**KIRKLEES METROPOLITAN COUNCIL
INVESTMENT & REGENERATION SERVICE**

**DELEGATED DECISION FOR DISCHARGE OF CONDITION A.4 -
NOTIFICATION OF A PROPOSED ENLARGEMENT TO DWELLINGHOUSE**

| Reference no. | 2024/HH/93436/W |
| Site Address | 5, Stone Acre Heights, Meltham, Holmfirth, HD9 4EF |

GENERAL ARRANGEMENT AS PROPOSED FLOOR  
PLANS & ELEVATIONS

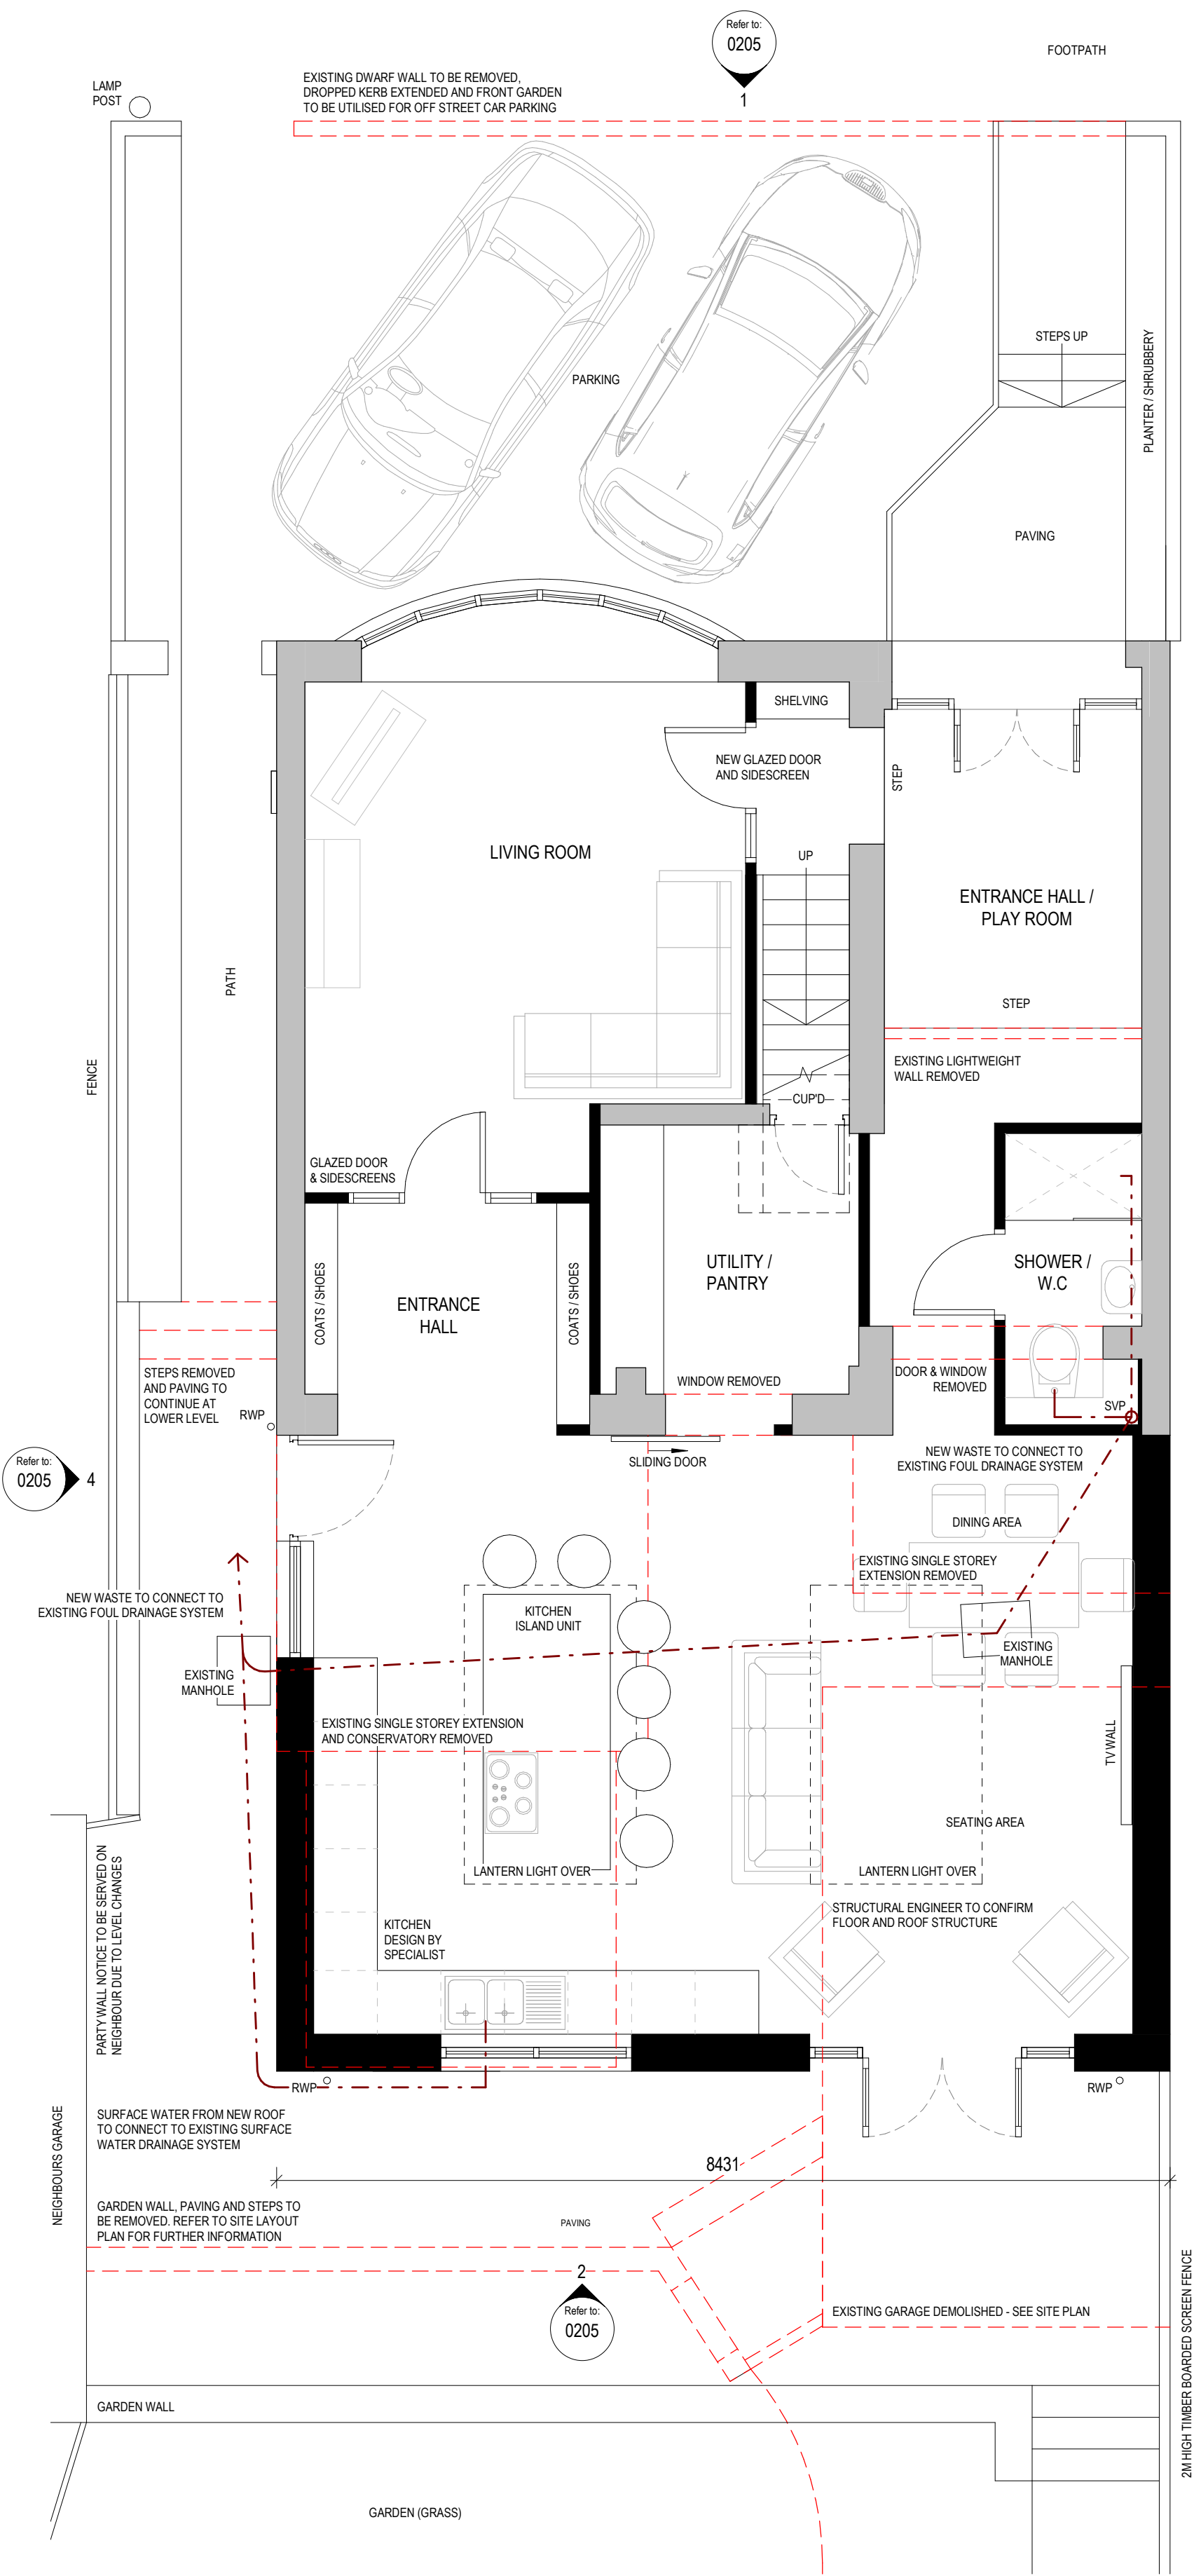
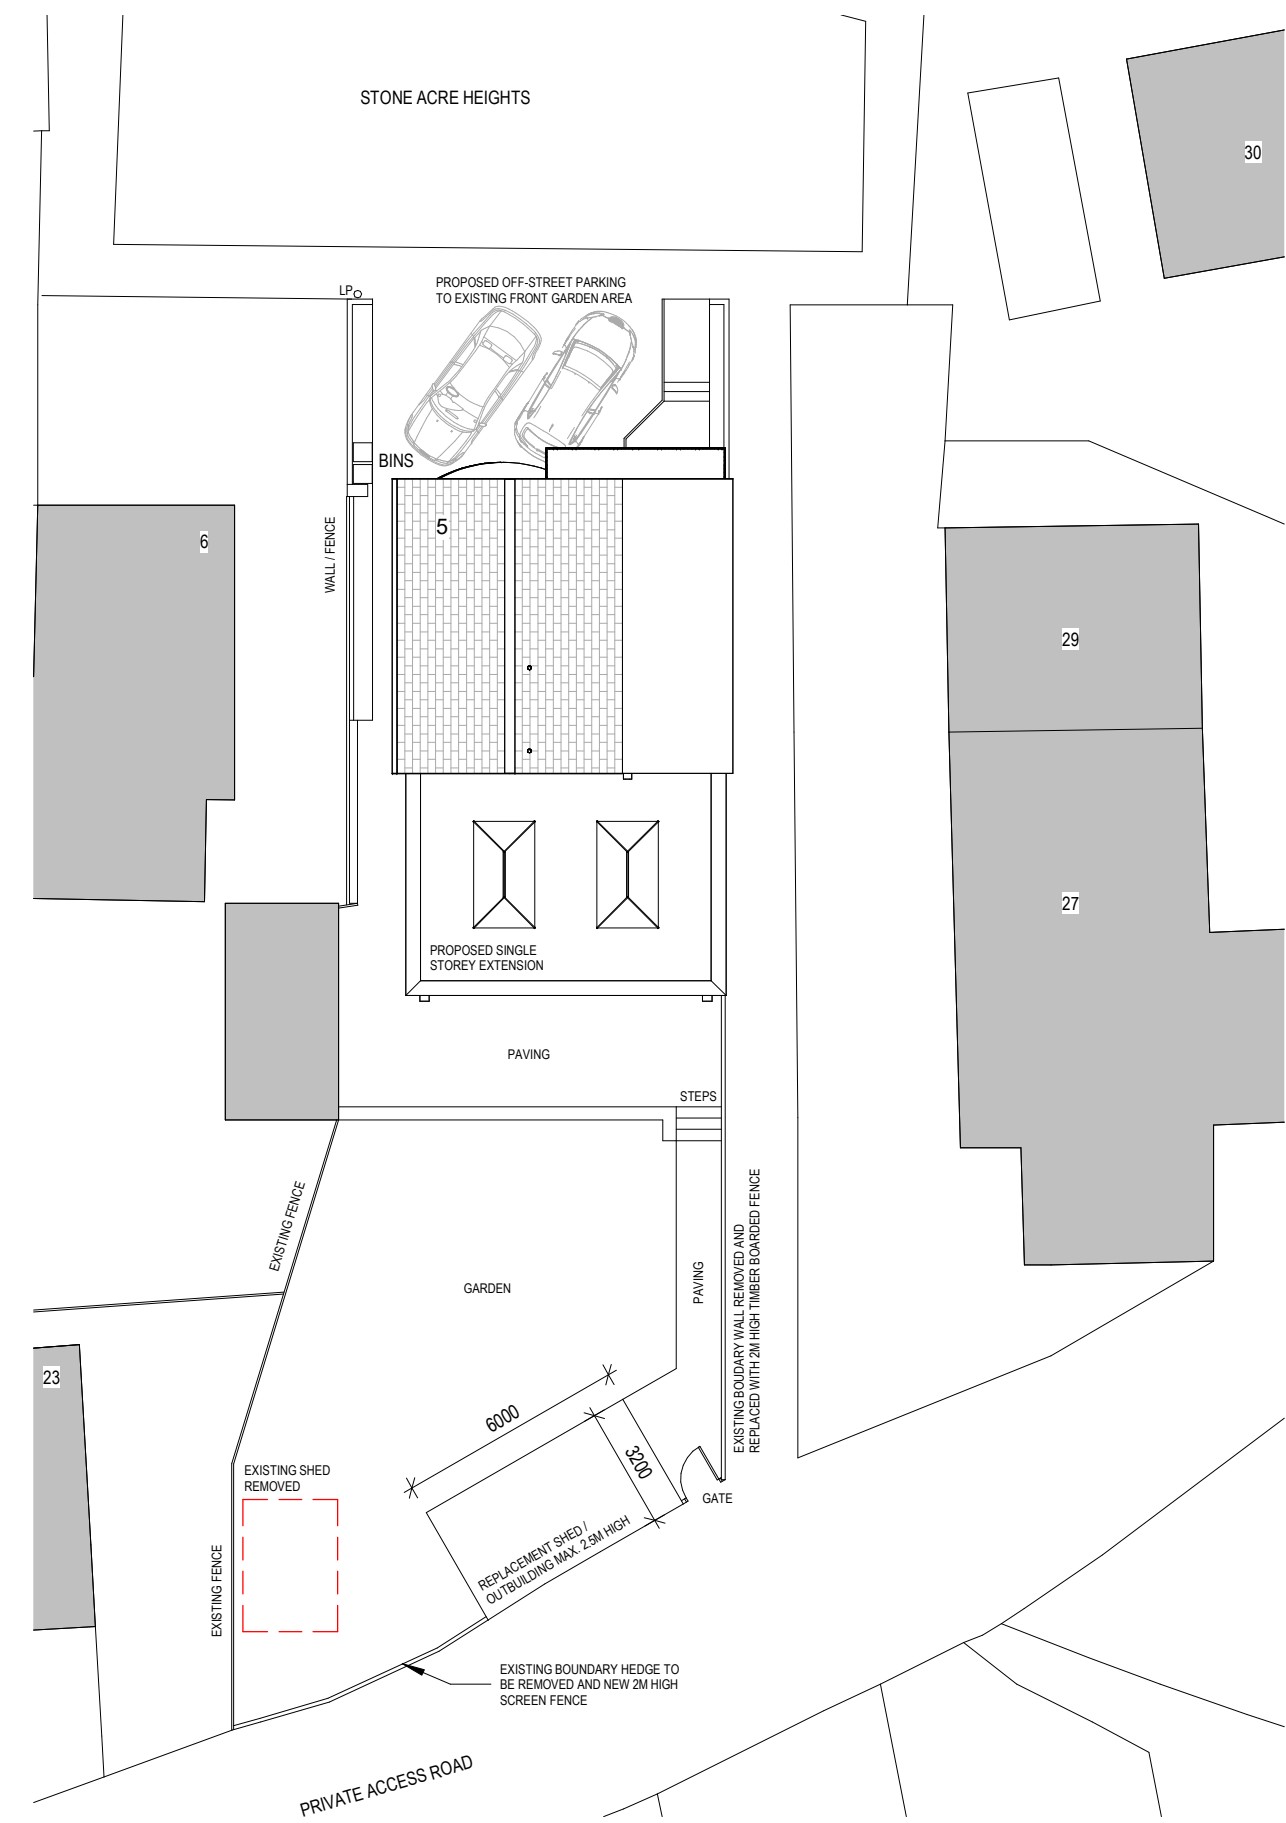
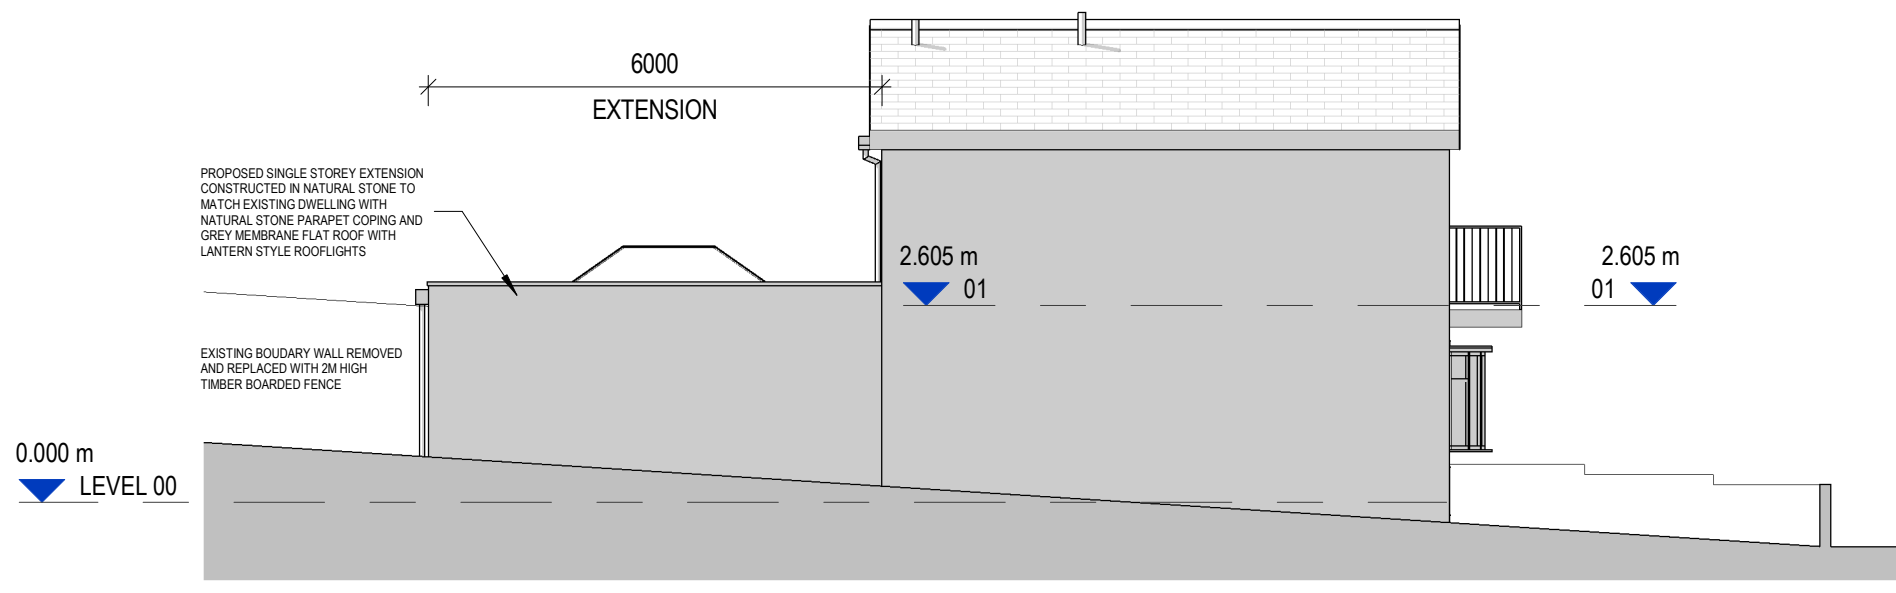
The proposed extension projects from the rear of the original dwellinghouse by 6 metres along part of the rear elevation and beyond an existing part rearward projection. The Council's historical imagery dated 1955 does not show the dwellinghouse to have been built. However, imagery dated 1956 indicates the existing rearward projection was original to the dwellinghouse.

Although it appears that more recent rear extensions have been added since the original rearward projection the original rearward projection nonetheless extends beyond a wall forming a side elevation of the original dwellinghouse. Having regard to the Government's householder guide to permitted development rights (2019) and sub-paragraph A.1(j), Class A, Part 1 of Schedule 2 of the Town and Country Planning (General Permitted Development) (England) Order 2015 (as amended) development is not permitted under Class A where the proposed extension extends beyond a side elevation of the original dwellinghouse and has a width greater than

half the width of the original dwellinghouse. In this case the submitted plans indicate the proposed extension extends along the whole rear elevation of the property and is therefore contrary to paragraph (j) of Class A and as such cannot benefit from a permitted development.

The proposed enlargement does not benefit from a general planning permission under Article 3(1) and Class A, Part 1 of Schedule 2 of the Town and Country Planning (General Permitted Development) (England) Order 2015 (as amended) as the rear projection extends beyond a wall forming a side wall of the original dwellinghouse and has a width greater than half the width of the original dwellinghouse contrary to sub-paragraph A.1(j) of Class A.
